Hillingdon Council's Comment (Noise)

1) Noise – Clarifications and justifications needed (comments below)

Appendix F: Noise Maps

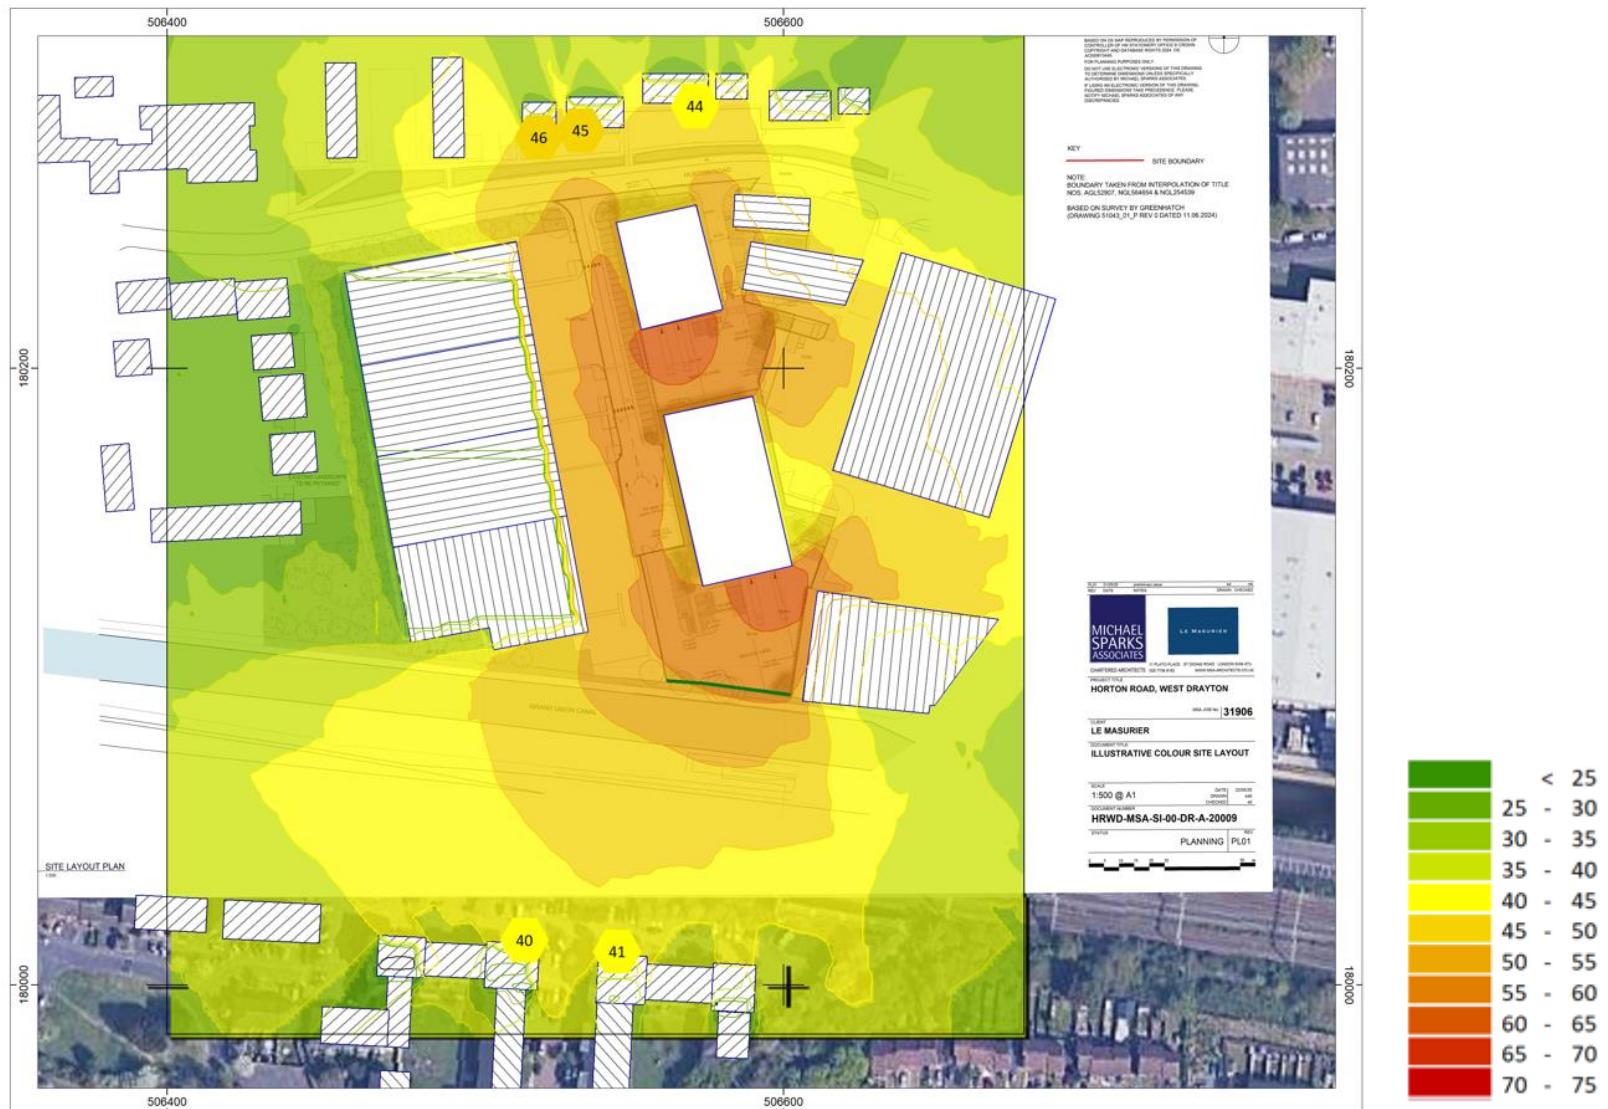
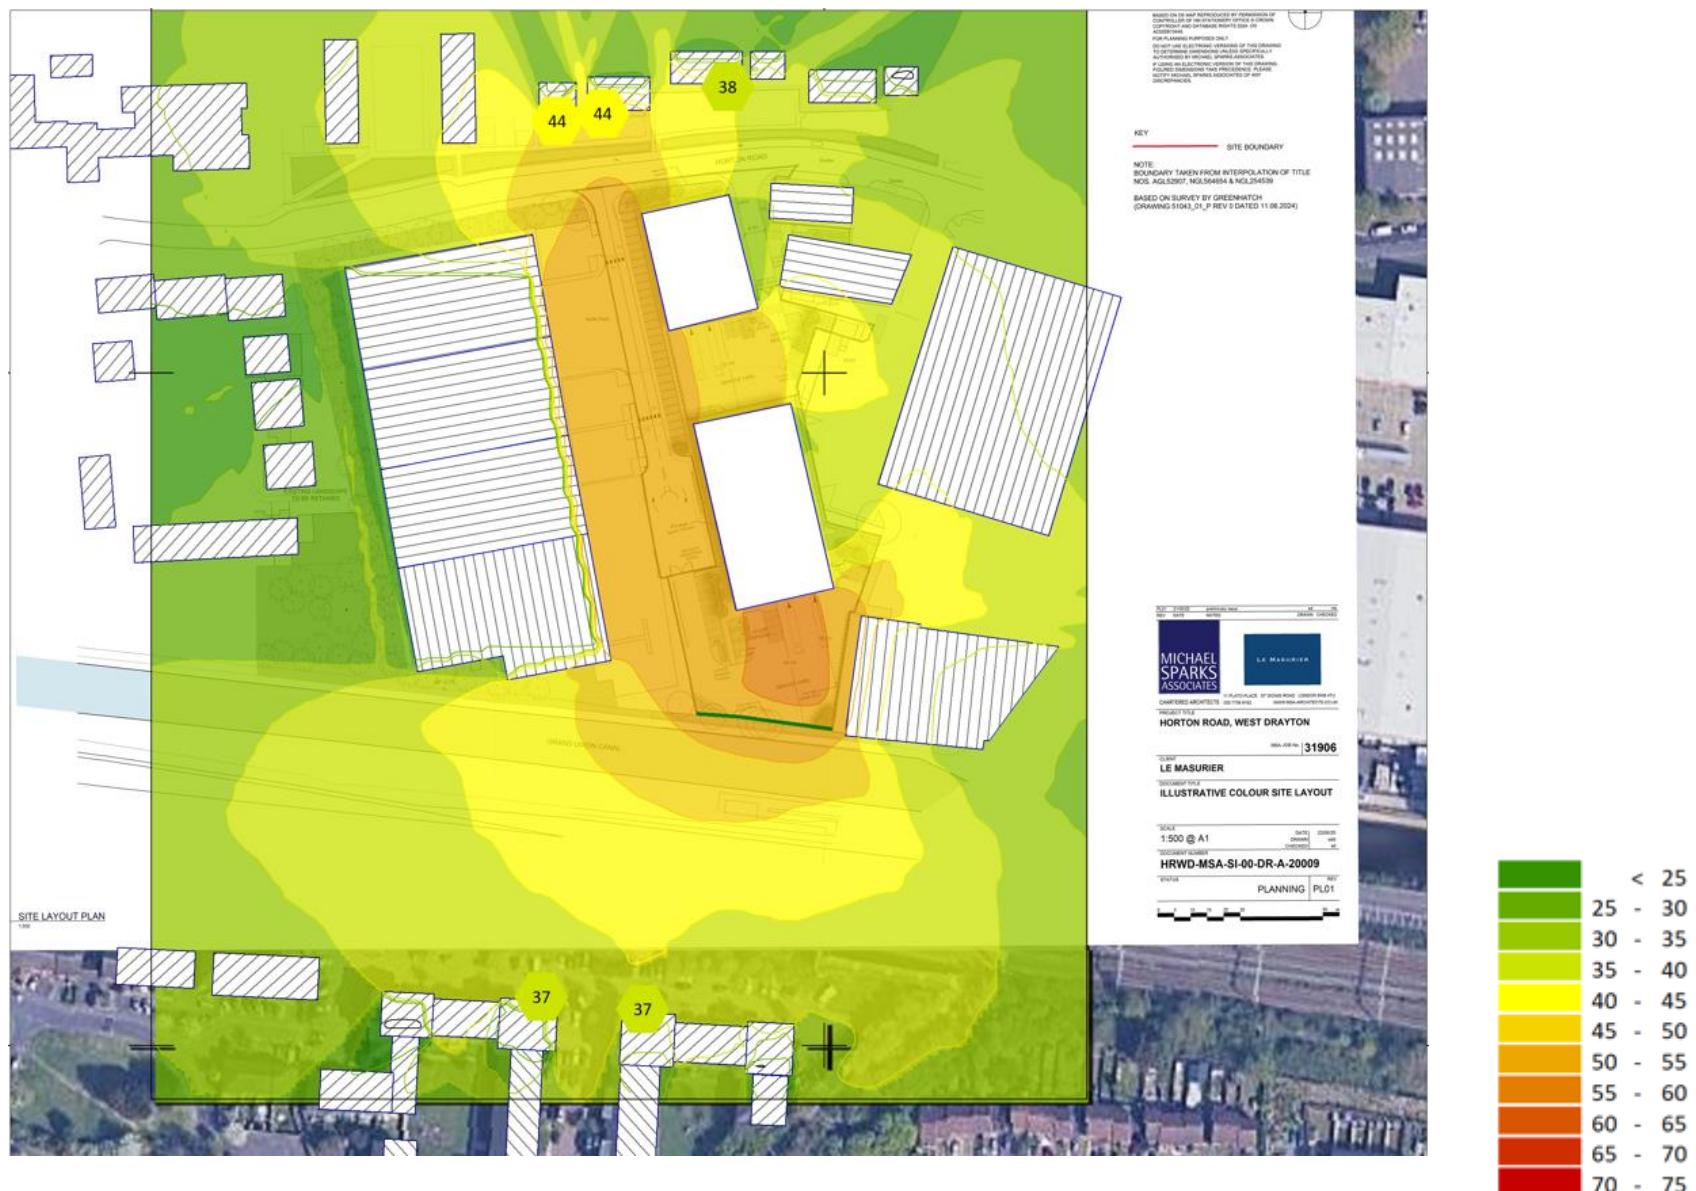
The rebuttal suggests that a single delivery by a van during the night-time hours would breach the proposed condition, and therefore the condition is unreasonable given the nature of the facility.

However, it is not clear how that has been calculated, for example would that be the case for an electric or hybrid van and how would that be unreasonable?

There is a somewhat separate question as to whether it would be within the scope of any assessment. The general principle being that whilst on the public highway the noise contribution would not be included in the assessment. Perhaps the applicant could provide some further justification for the modification or propose some additional words to clarify matters around this.

The assessment was calculated using the movement of a service vehicle from the edge of the application site (adjacent to the public highway) to the servicing area, loading/unloading of the vehicle and its return back to the red line boundary, where it then enters the adopted highway.

We have not considered the noise associated with movement of the vehicle when it is on the public highway in the BS4142 assessment as this is outside of the scope of the assessment, as highlighted by the Council. As a public highway, there are no restrictions on vehicle movements along it, so no restriction can be placed on vehicles using this.

The below screen grab illustrates the noise modelling associated with this scenario of a single service vehicle. This is based on a combustion engine vehicle.

This noise level taken at the properties on the other side of Horton Road in this modelled scenario is $L_{Aeq,15mins}$ 44dBA. On this basis, the noise associated from movement of the vehicle and the associated delivery/servicing activities would be indistinguishable when considered against the character of the existing noise climate that was measured during the noise survey.

Therefore, in BS4142 terms, the noise impact would be low during both the daytime and night time periods.
